MEADOWBROOK PARK
PLANNED UNIT DEVELOPMENT (PUD) AND PRELIMINARY PLAN
LOCATED IN THE SOUTHEAST 1/4 OF SECTION 8, T14S, R65W, OF THE 6th P.M., EL PASO COUNTY, COLORADO

County File Number: PUDSP208

MEADOWBROOK PARK
PLANNED UNIT DEVELOPMENT (PUD) PLAN

**F SCREEN WALL DETAIL**  
N.T.S

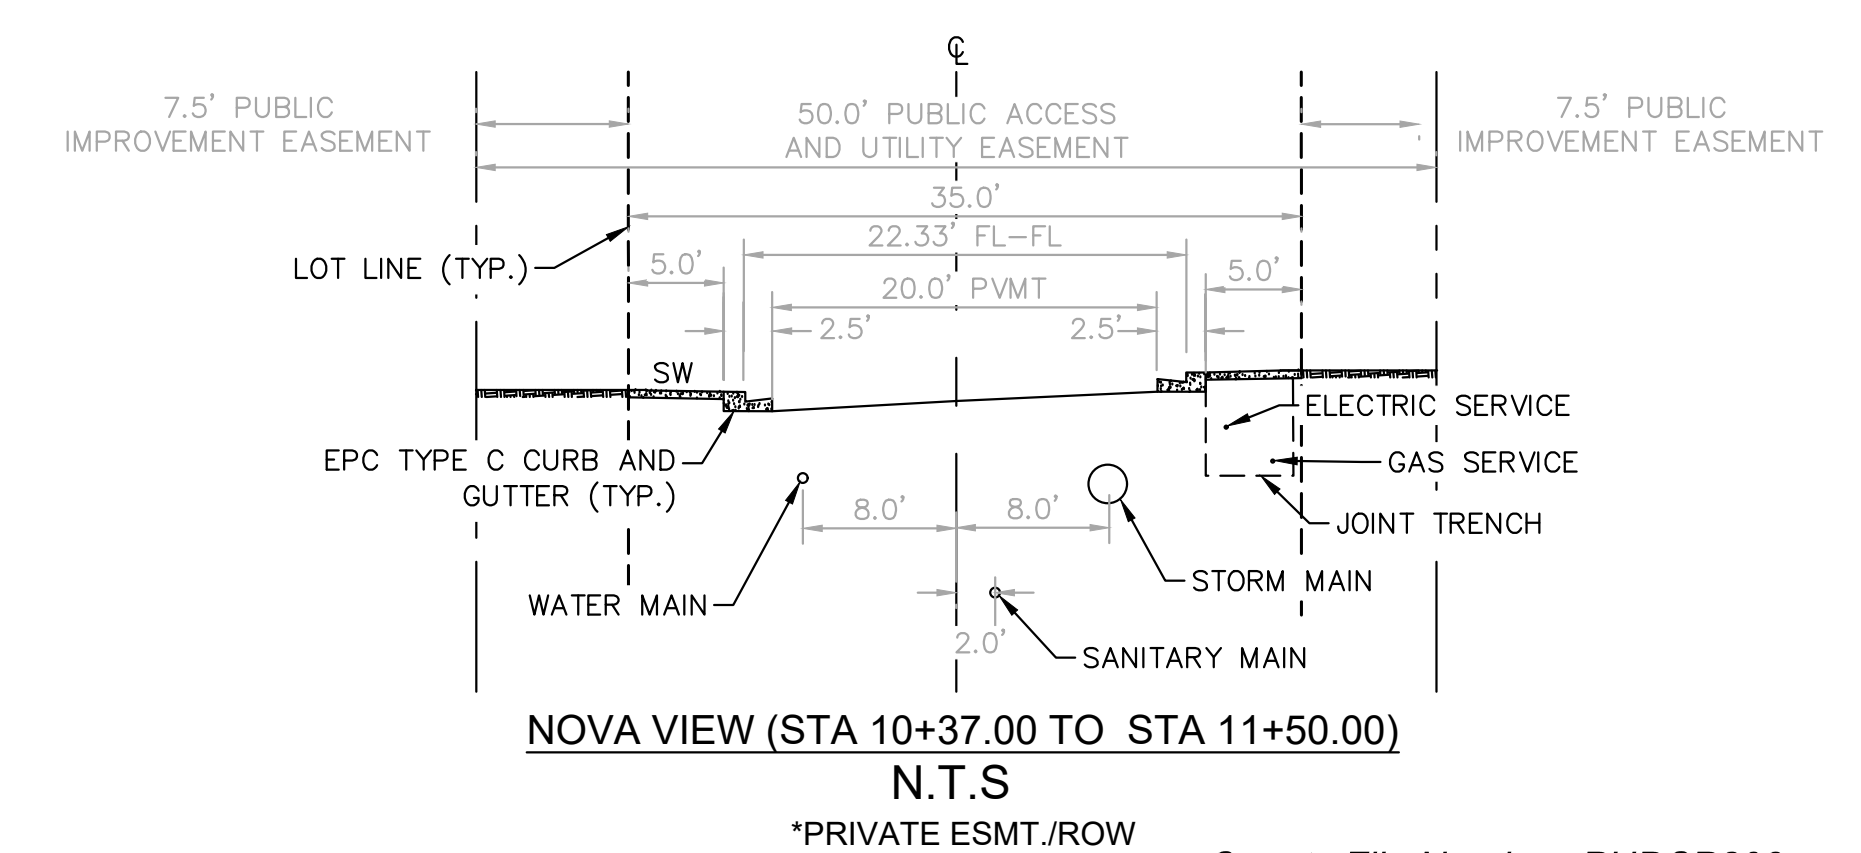
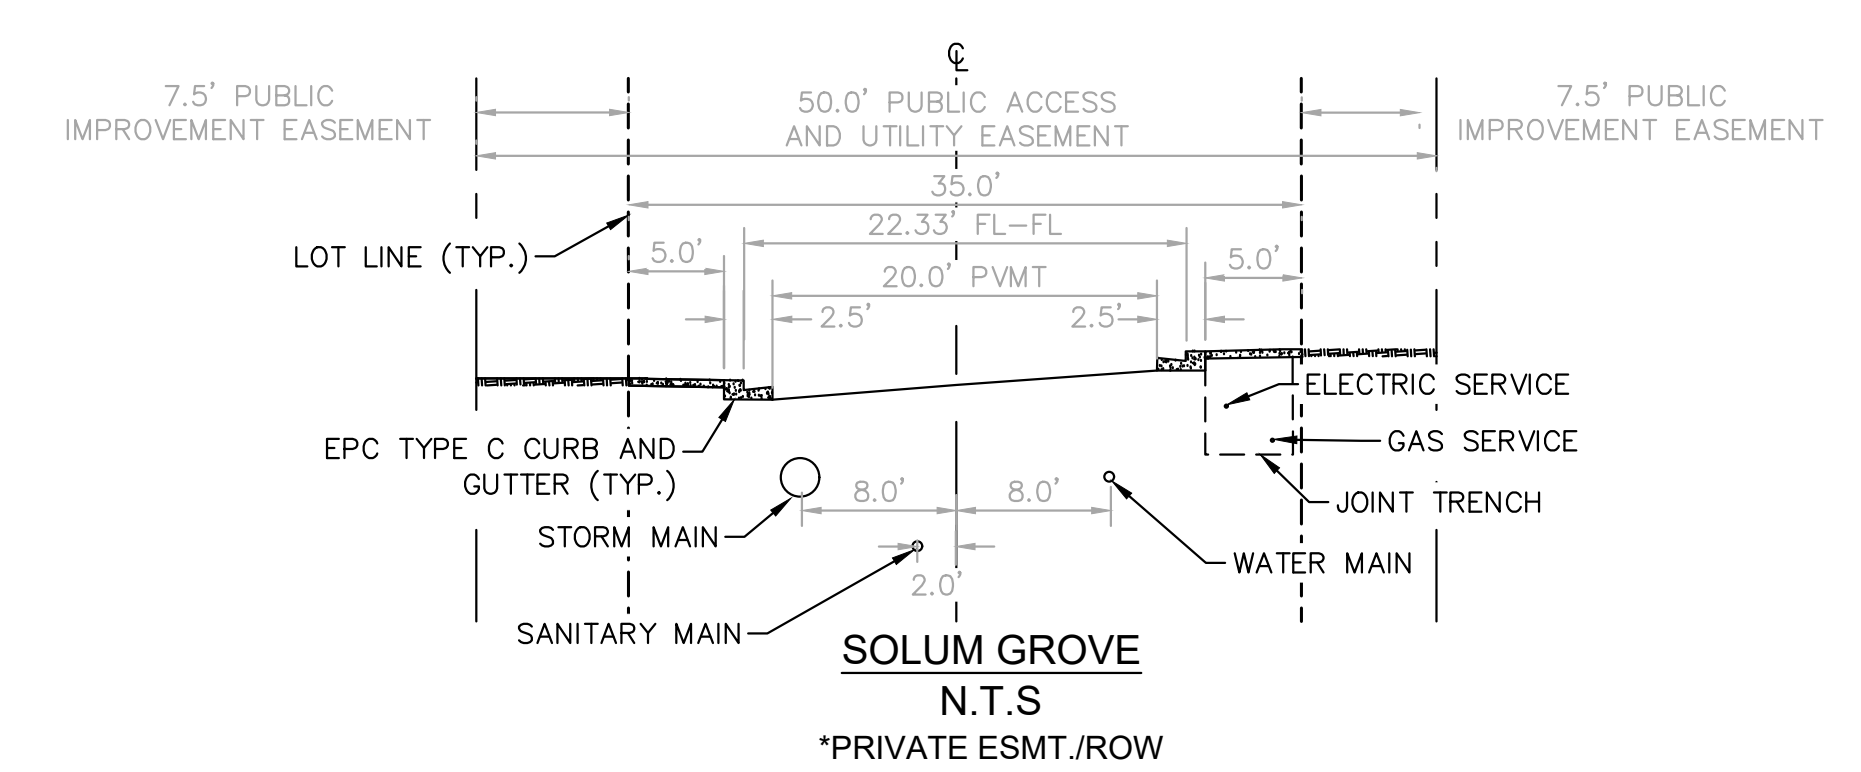
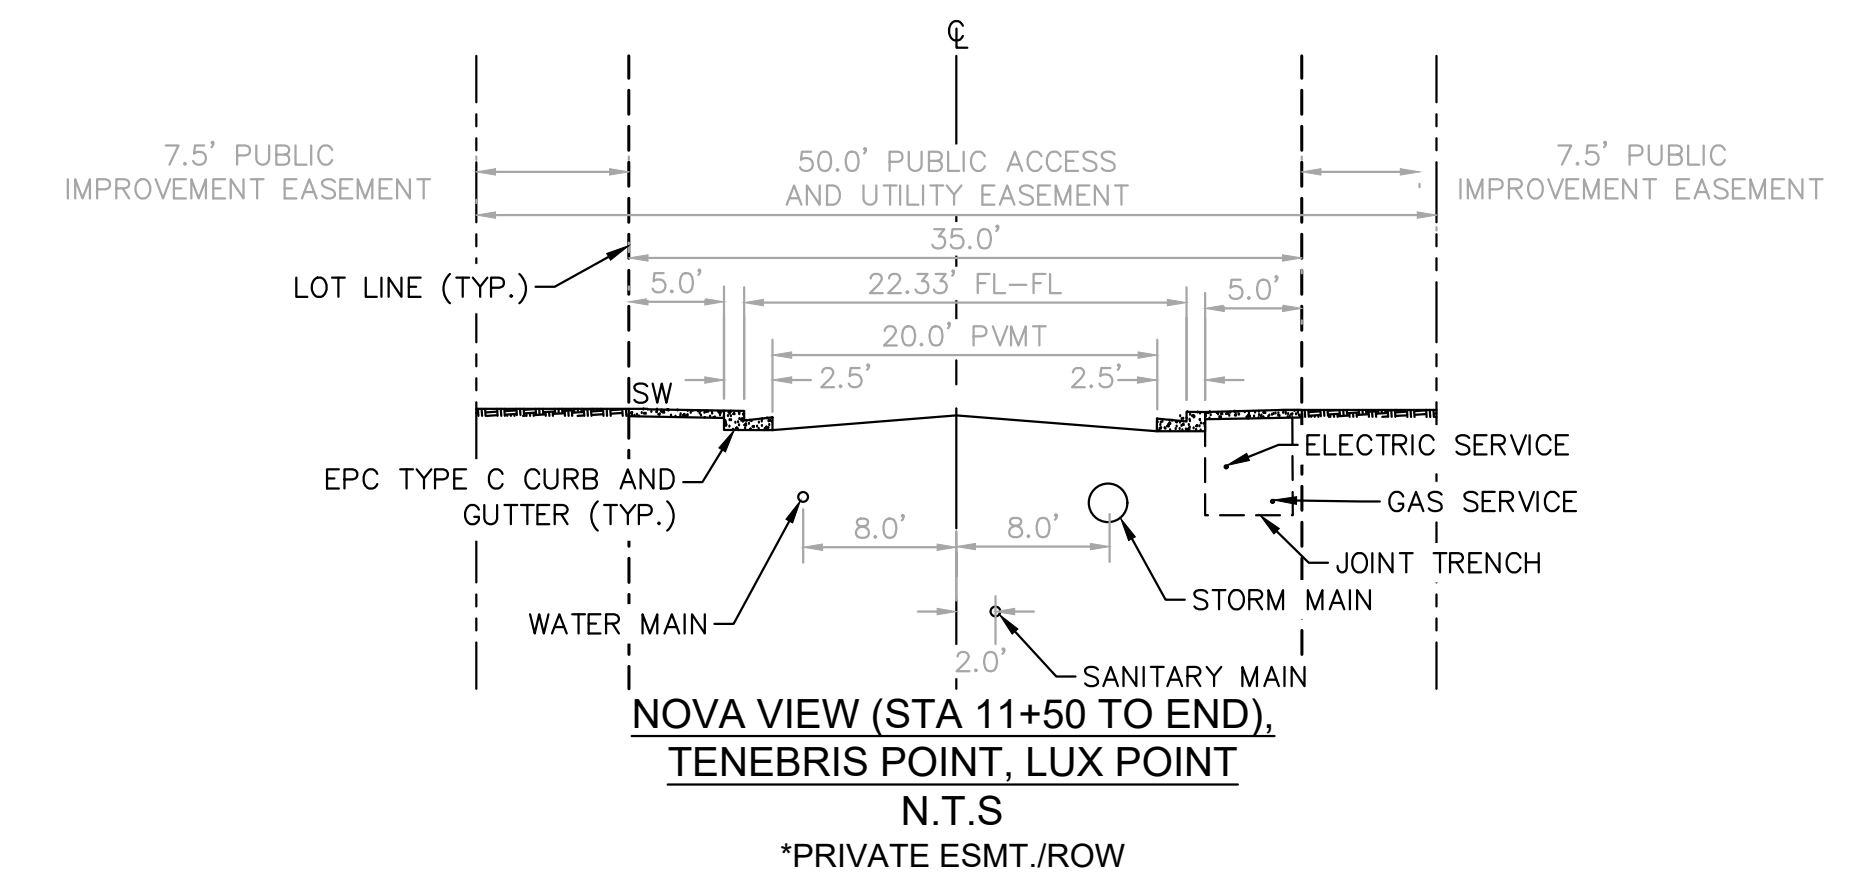
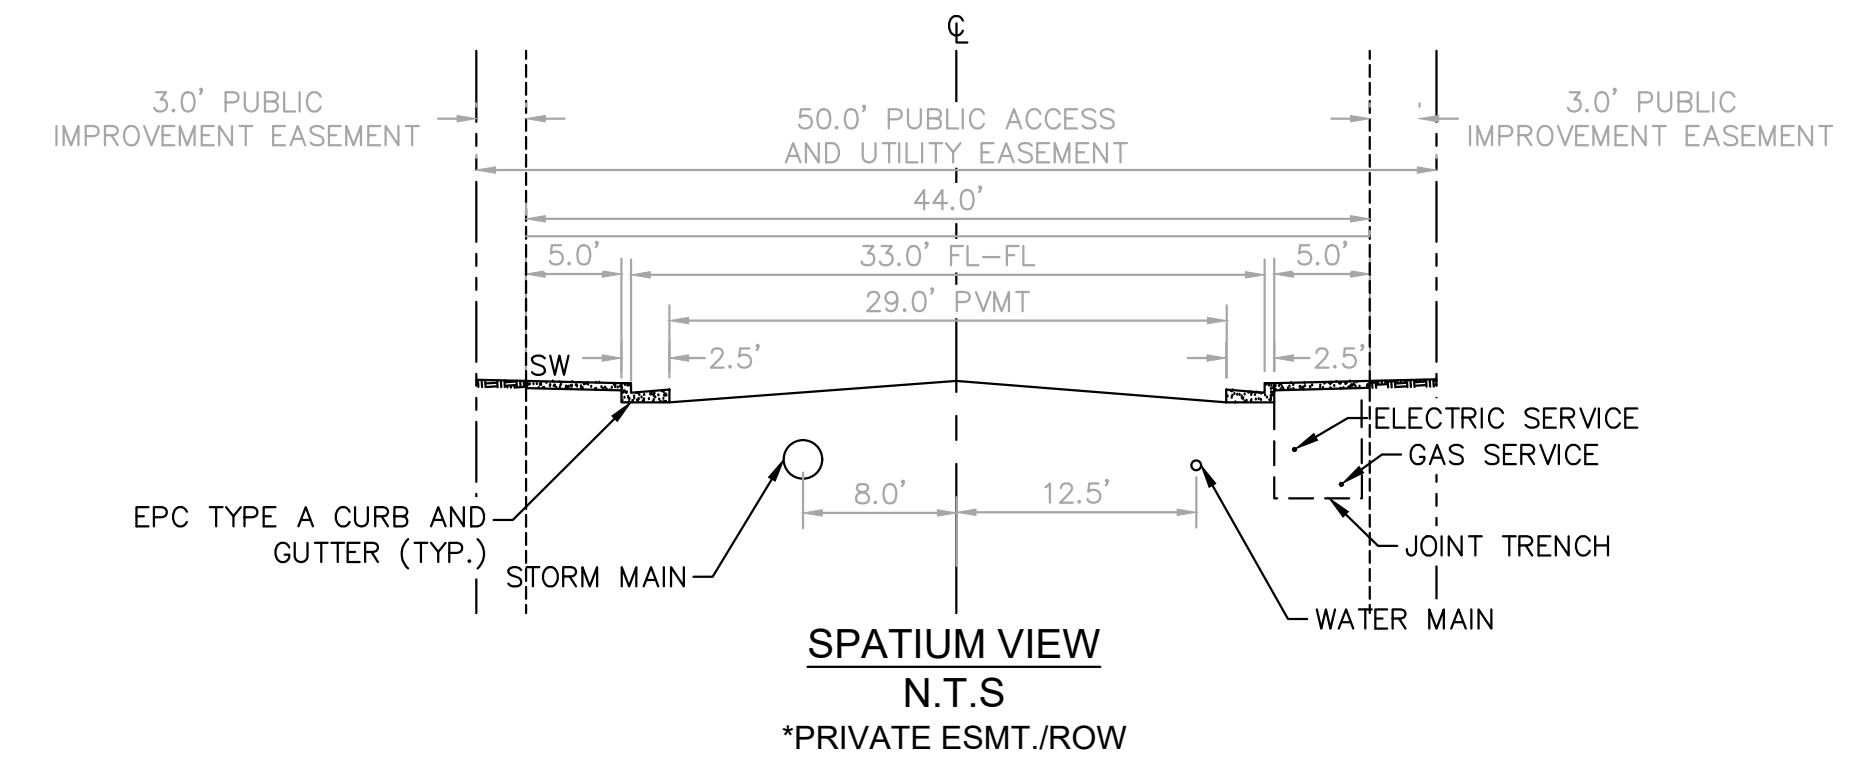
Label and provide NOISE wall
